Doc Ref: WC510-06F02(rev1)- WS Memo

Date: 7 October 2016

**RE: CAMPBELL'S STORES, SYDNEY HARBOUR
PEDESTRIAN WIND STATEMENT MEMO**

Drawing Title:
SECTION - BAY 12 NORTH

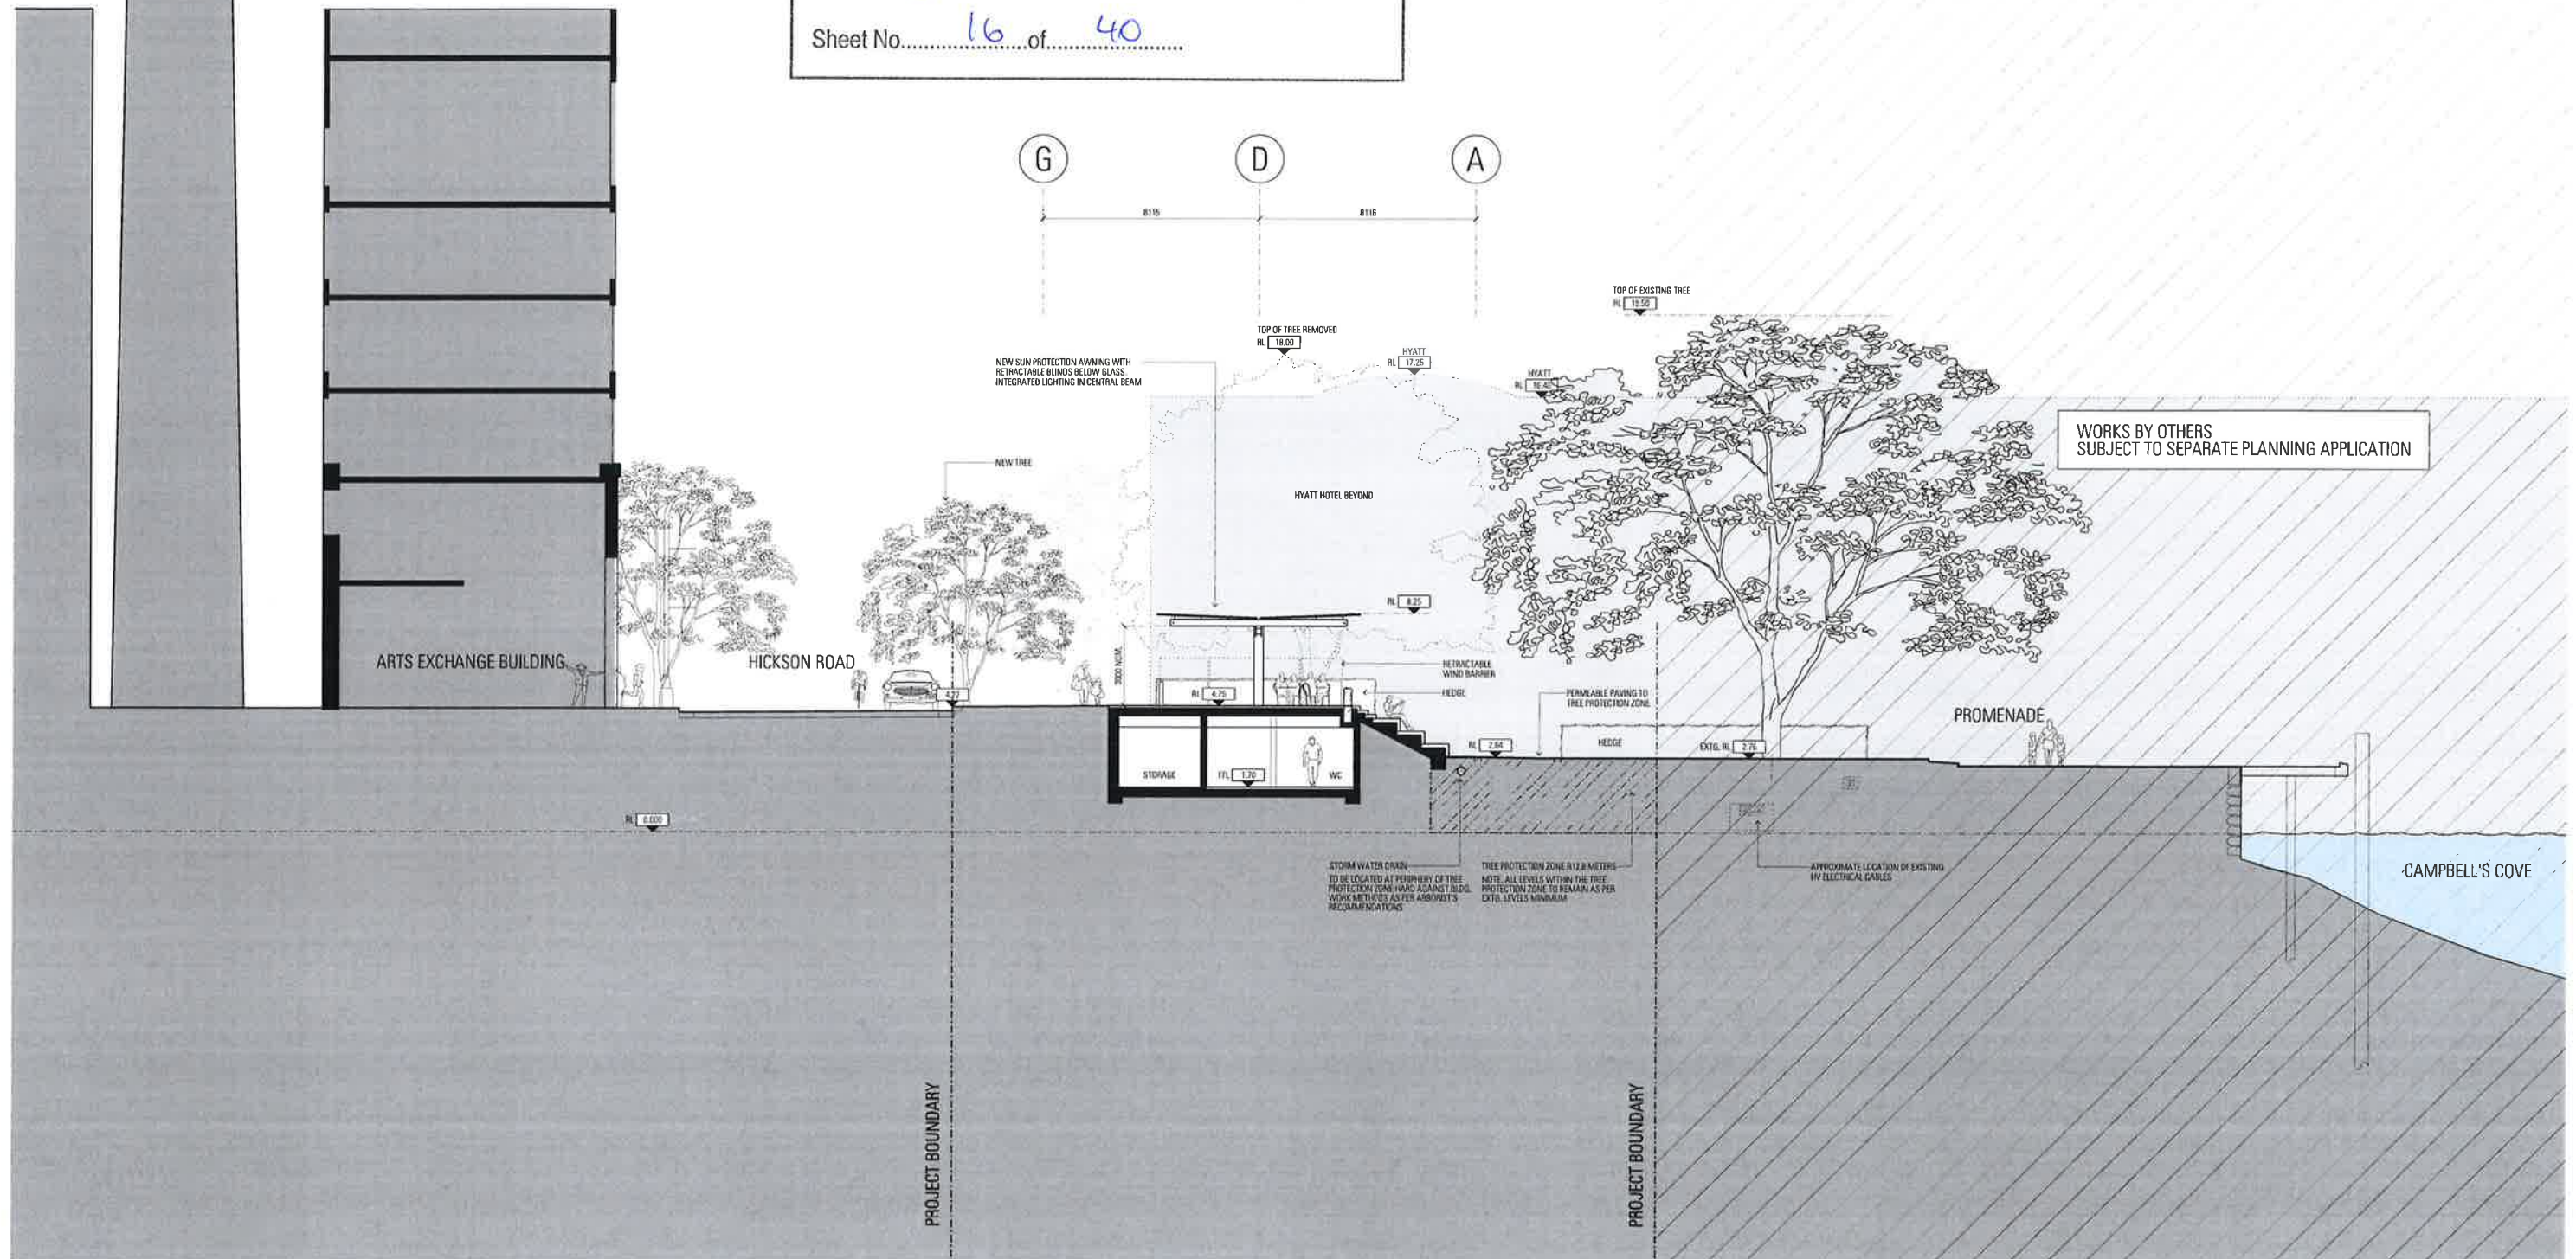
Since the time of the desktop assessment, further architectural changes have been made to the design of Bay 12 as per the latest drawing set received September 2016. The glass block structure has since been replaced in favour of an outdoor seating area with an impermeable glass awning structure above and densely foliating hedge planting proposed along the perimeter.

A desktop review has been carried out and it is expected the wind conditions within and around the outdoor seating area are expected to remain similar or better than the existing wind conditions the inclusion of the proposed changes to Bay 12. The proposed planter boxes and retractable screens along the northern edge of the outdoor dining area are expected to be effective in enhancing the localised wind conditions. The planter beds and retractable screens act as an effective wind mitigating element, capturing the up-stream north-easterly to westerly winds and reducing the intensity of the wind effect before it reaches the outdoor dining area. It should be noted the planter bed are recommended to be populated with densely foliating shrubs or hedge planting. Furthermore, we can confirm no further wind barriers are required along the Hickson Road or Promenade interfaces. The wind conditions along these areas are expected to be similar or better than the existing wind conditions with the inclusion of the proposed densely foliating trees along Hickson Road and the retention of the existing densely foliating fig tree and hedge planting along the promenade.

The proposed outdoor seating area adjacent to the existing densely foliating fig tree along the promenade may experience relatively higher wind effects from the existing north-easterly winds travelling over the open waters of Campbell's Cove. As the north-easterly winds occur most frequently during the warmer months of the year, the wind breezes are usually welcomed within outdoor areas since they are typically not as strong as the southerly or westerly winds. The patron comfort level is expected to be reasonable without need of additional wind barrier protection, and a review of the wind roses by the Bureau of Meteorology; attached within the appendix of this memo, indicates the wind occurrence is limited to the months of October-March, and typically during the afternoon periods of the day.
